Department for  
Business, Energy  
& Industrial Strategy

Our Ref: EN010095

Date: 14 October 2022

**Application by Alternative Use Boston Limited (“the Applicant”) for an Order granting Development Consent for the proposed Boston Alternative Energy Facility (“the Proposed Development”)**

TITLE
 BOSTON ALTERNATIVE ENERGY FACILITY
 DEVELOPMENT CONSENT ORDER
 Regulation 5(2)(k) - Access and Rights of Way Plan
 BOSTON BOROUGH COUNCIL
 Sheet 1 of 1

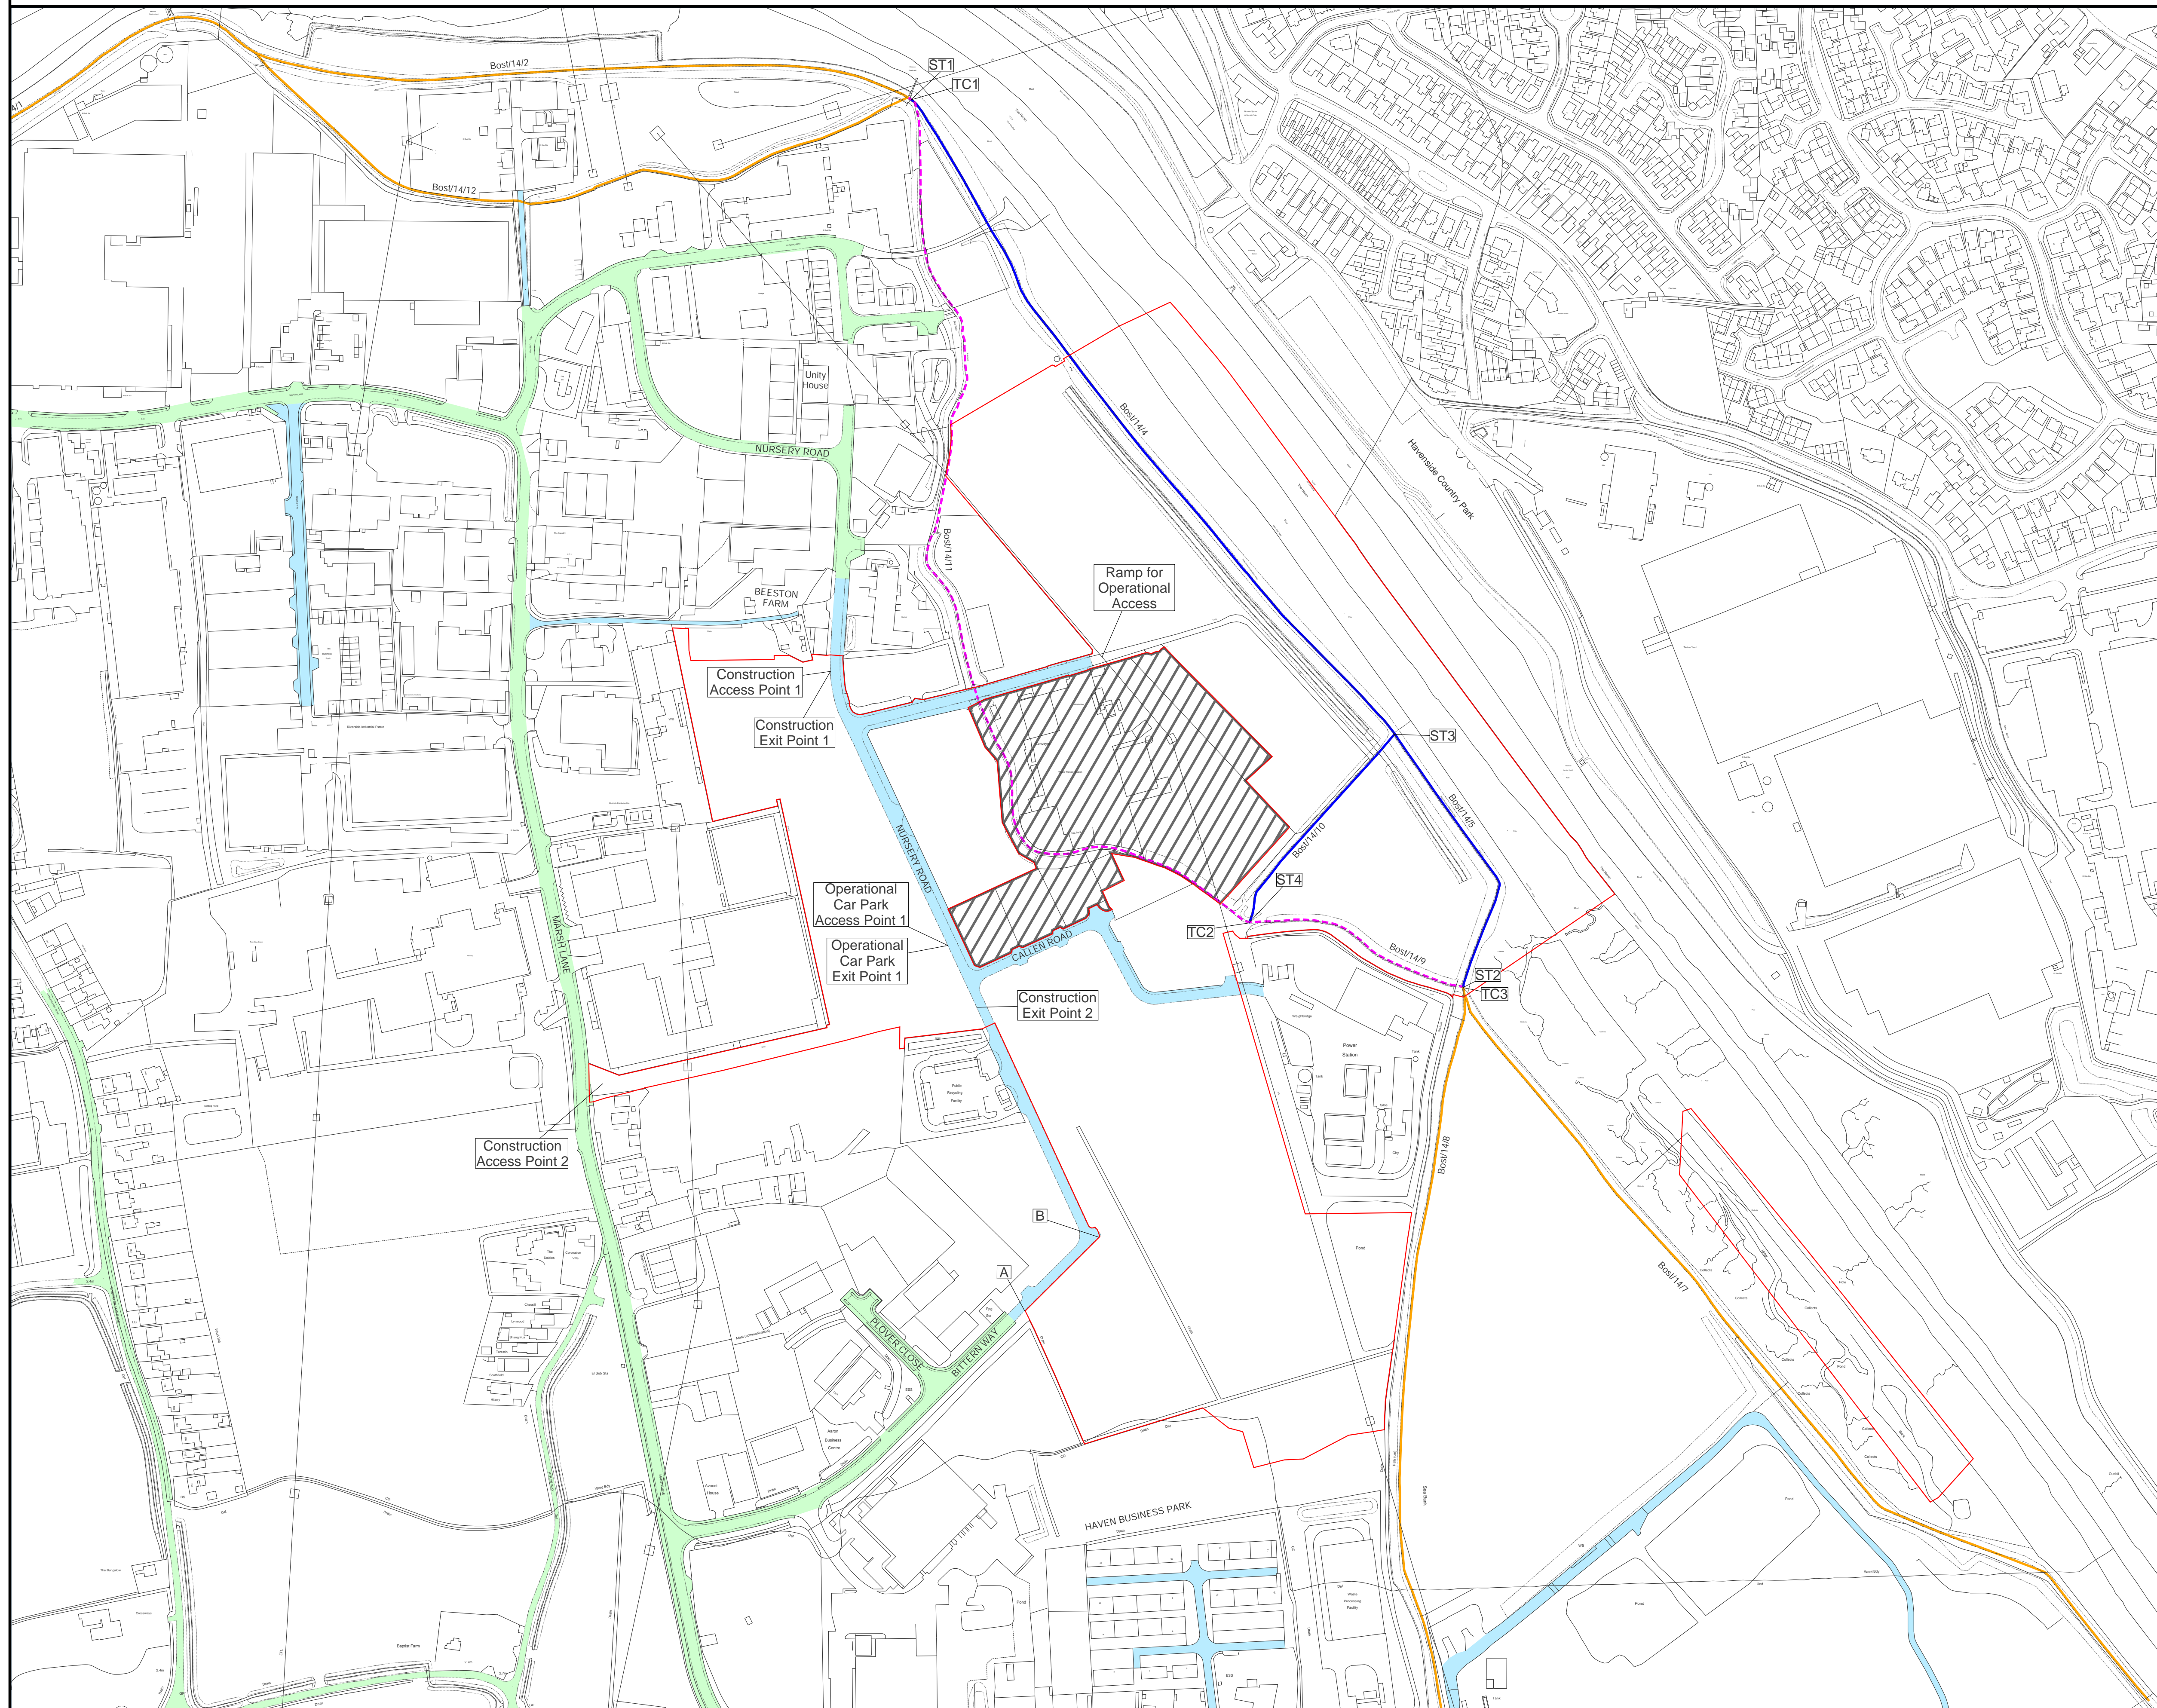
3.8. Is requested to provide a plan of Natural England’s suggested alternative to the proposed diversion route of the England Coast Path, as shown in Figure 1 of [REP2-047]. This is described in [REP5-015] as: *“This alternative would continue with approximately 200m of the northern section of BOST/14/4 and introduce a short new section of footpath (110m) which would join BOST/14/11.”*
